APPLICATION BY HIGHWAYS ENGLAND FOR AN ORDER GRANTING DEVELOPMENT CONSENT FOR THE A303 SPARKFORD TO ILCHESTER DUALLING

SUBMISSION MADE PURSUANT TO DEADLINE 6a

**Application by Highways England for the A303 Sparkford to Ilchester Dualling project
The Examining Authority's written questions and requests for information (ExQ3)
Issued on 25 April 2019**

Drawing Title
**FIGURE 11.5
NOISE LEVELS IN THE DO SOMETHING OPENING
YEAR LA10, 18HR [dB] - SHEET 1 OF 4**

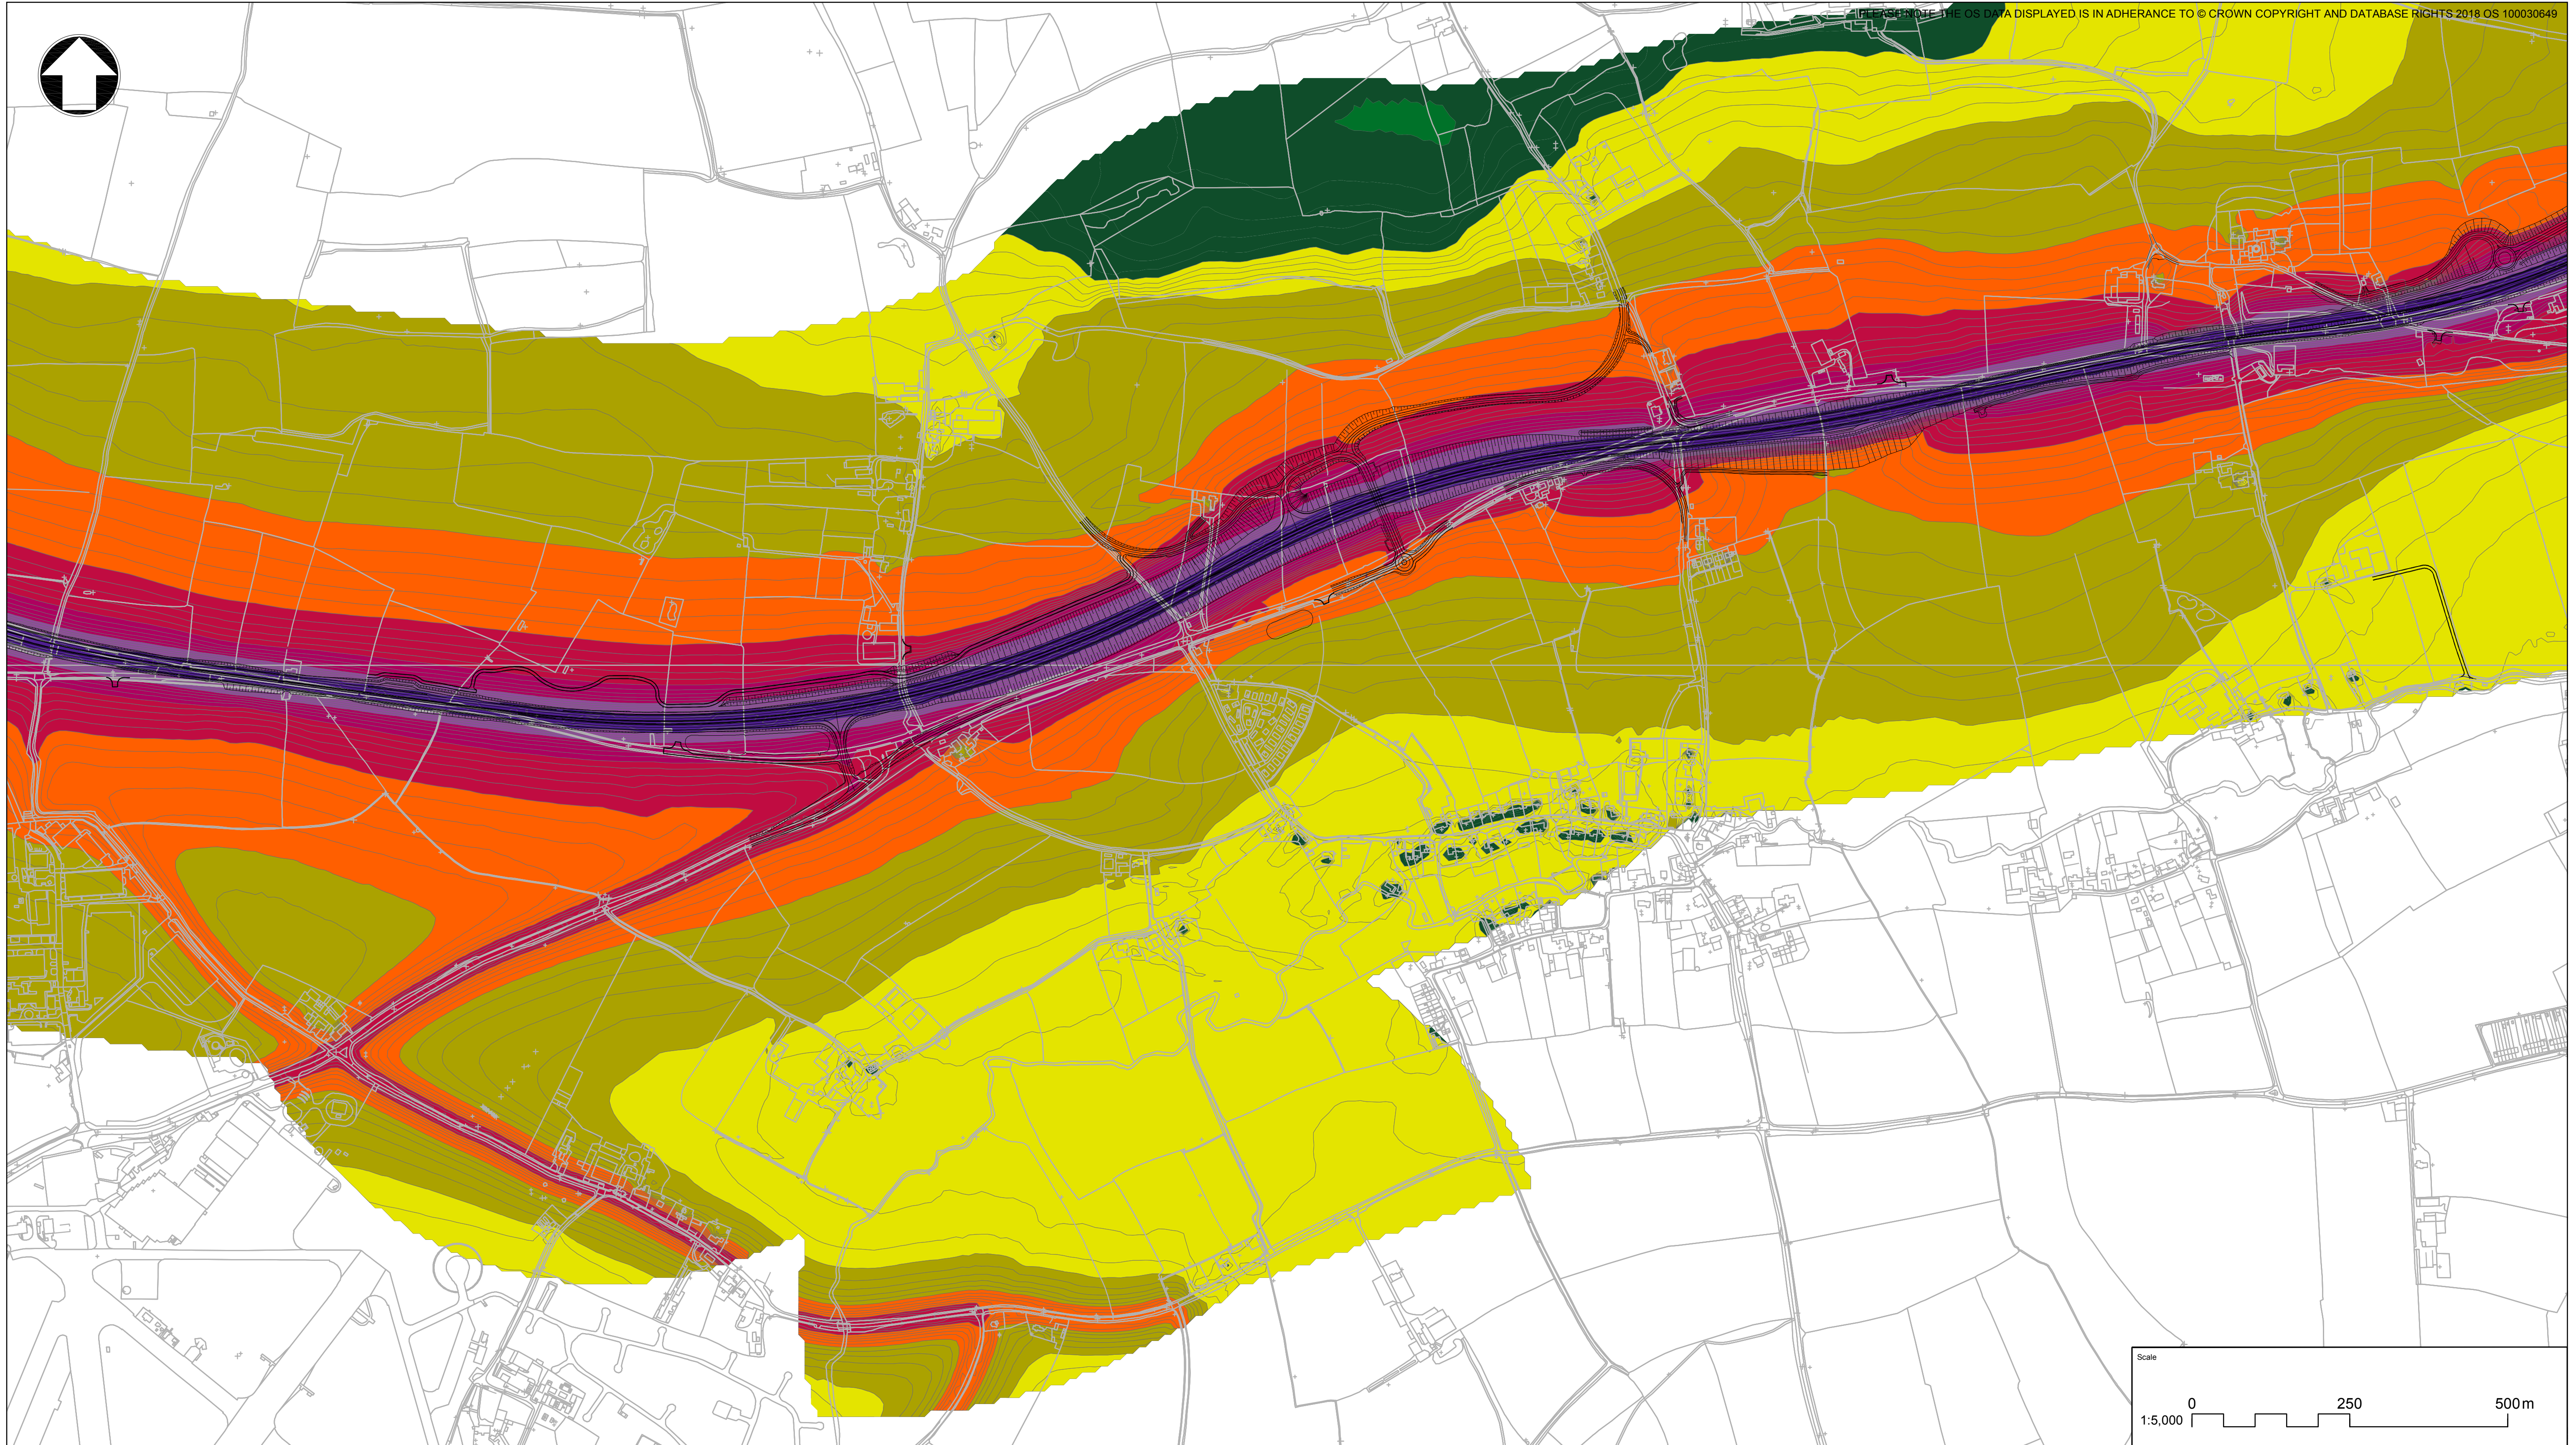
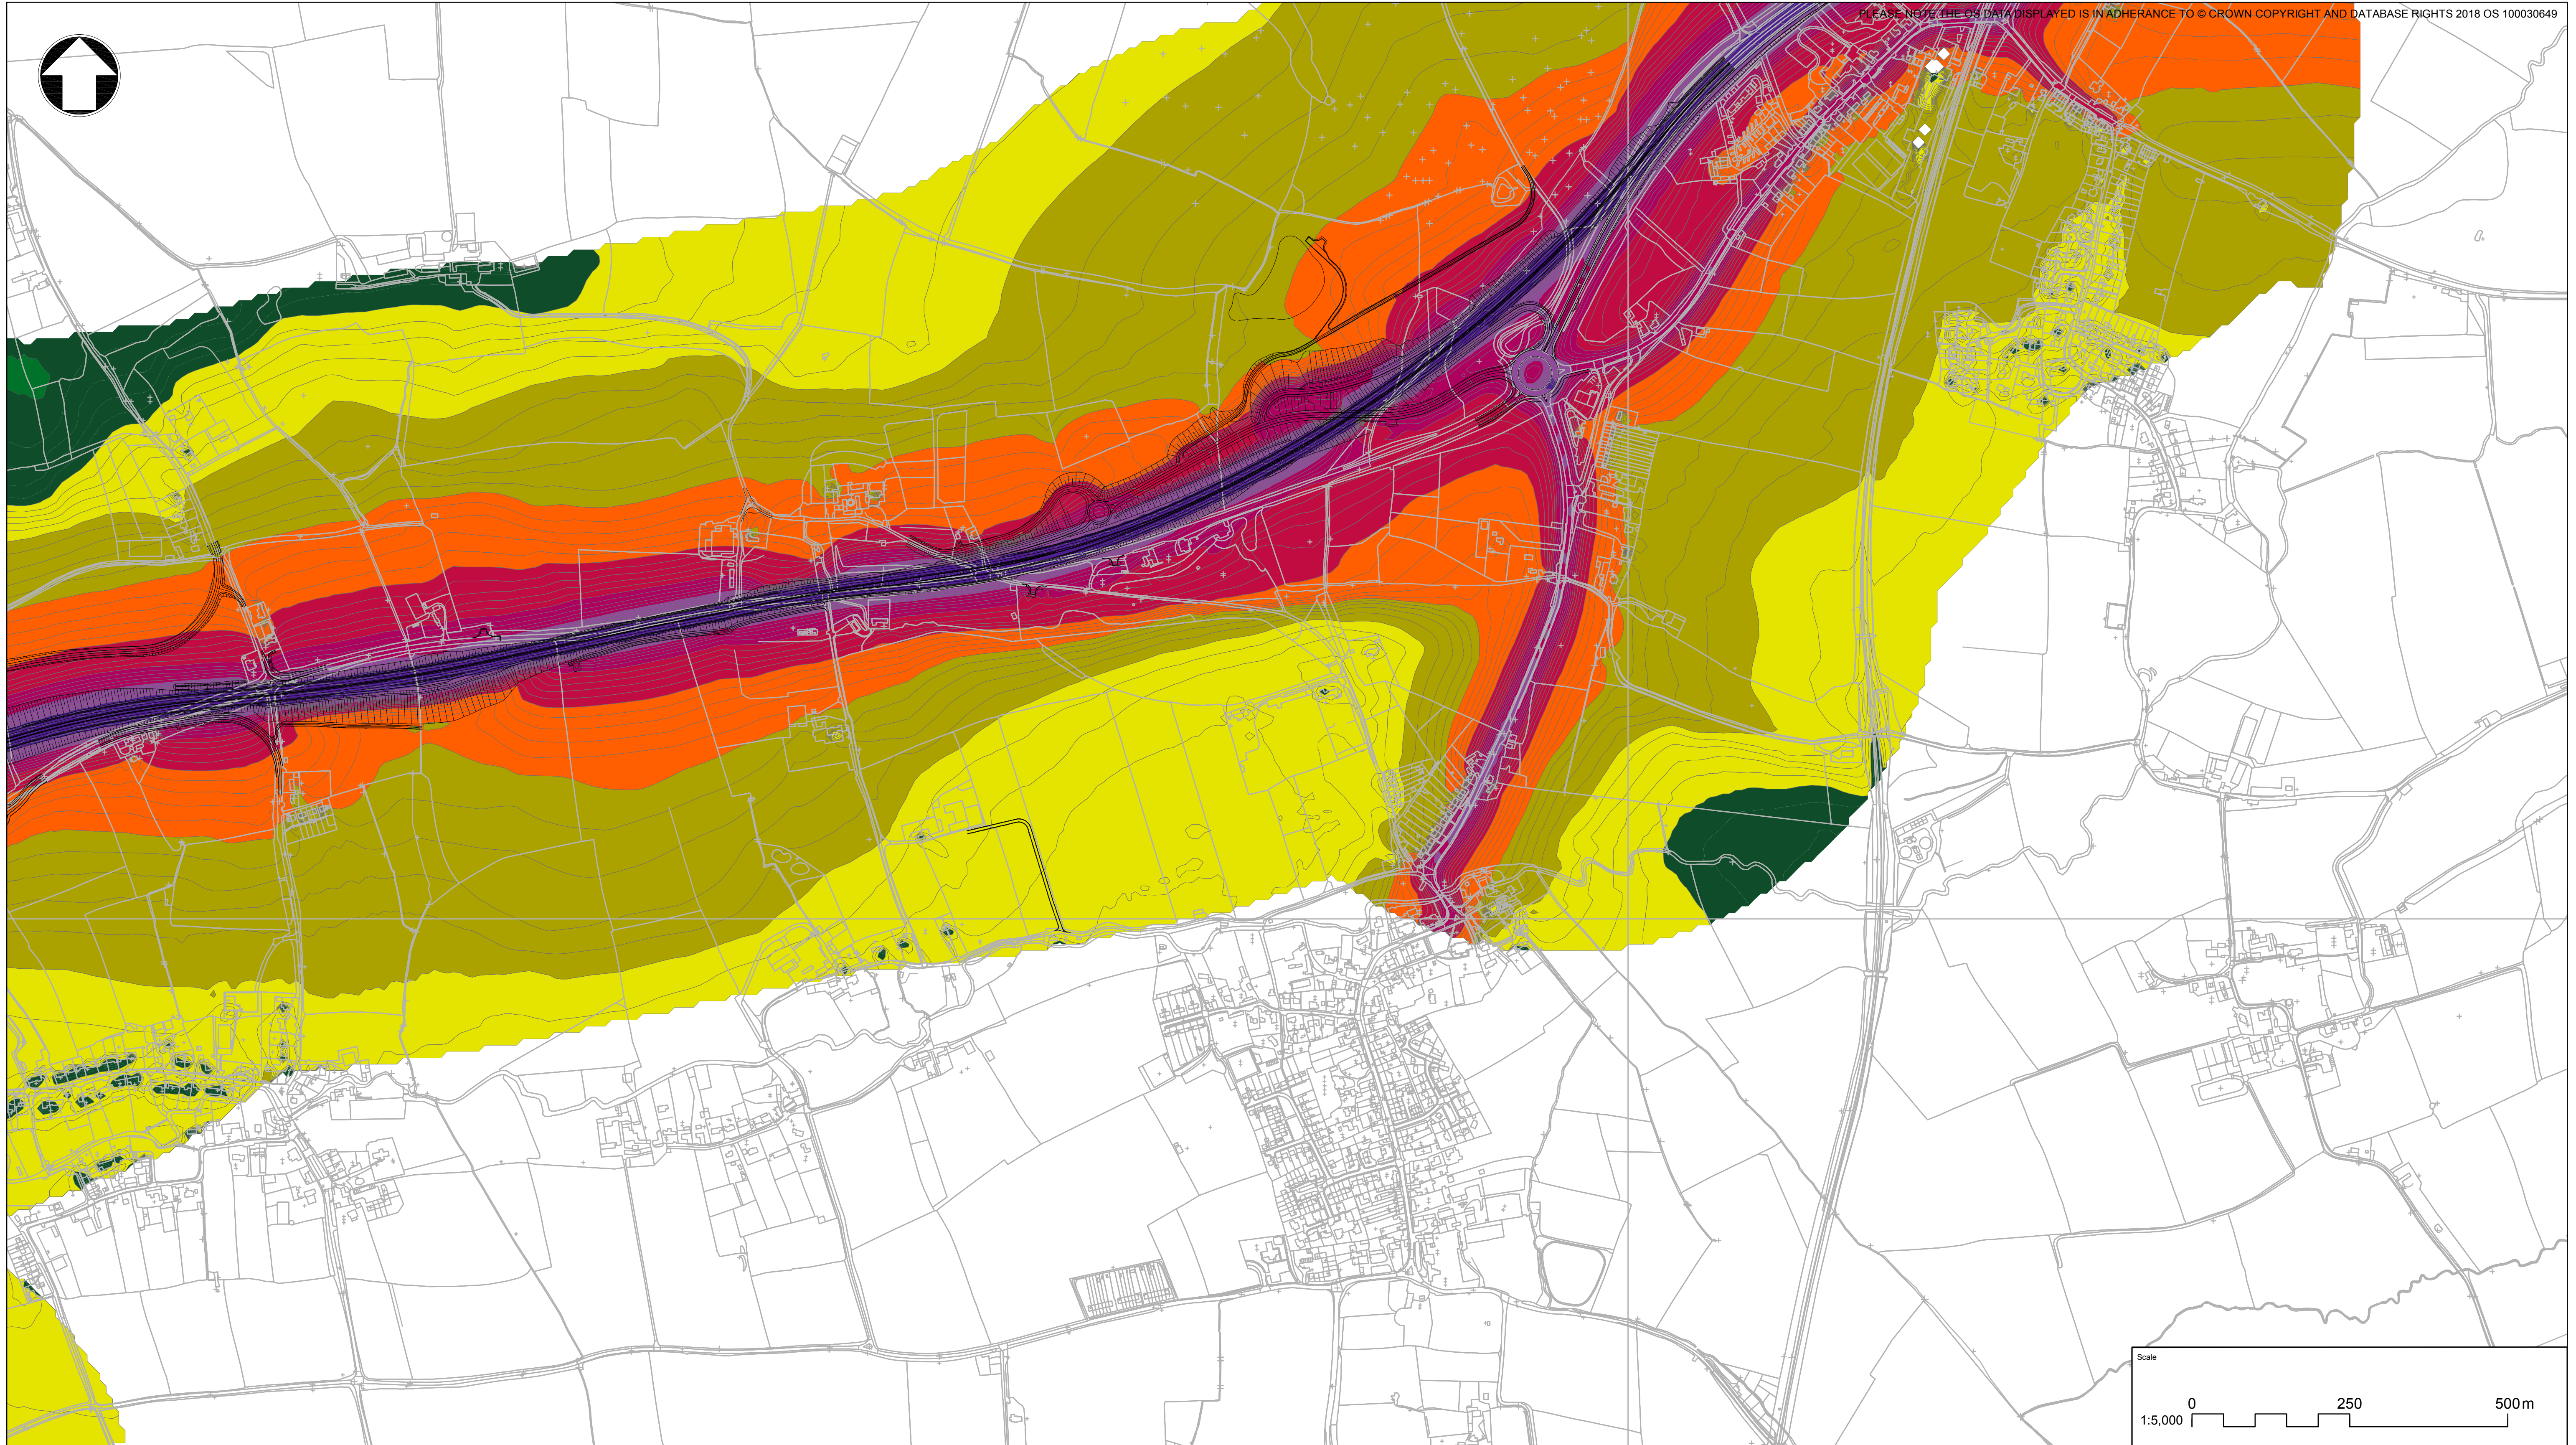
3.4	Noise and Vibration		
3.4.2	The Applicant SSDC	<p>Noise monitoring and Mitigation The ExA appreciates that the applicant's case is that the proposals will not have a significant adverse effect on the local communities in terms of noise.</p>	<p>Figure 11.5 in Chapter 11 Noise and Vibration of the ES confirms that two Noise Sensitive Receptors will be affected adversely – Annis Hill and The Spinney. The applicant is proposing that mitigation in the form of noise bunds and compensation towards secondary glazing and</p>

EXQ3	Question to:	Question:	SSDC Response
		Notwithstanding this, do the parties consider that there is a need to monitor and if necessary, mitigate the noise impacts post construction?	acoustic ventilation. SSDC is satisfied that this mitigation is sufficient to reduce to noise impact to acceptable levels. SSDC considers that it is necessary to monitor this action post construction to ensure that this mitigation has been delivered in line with the applicant's proposals.
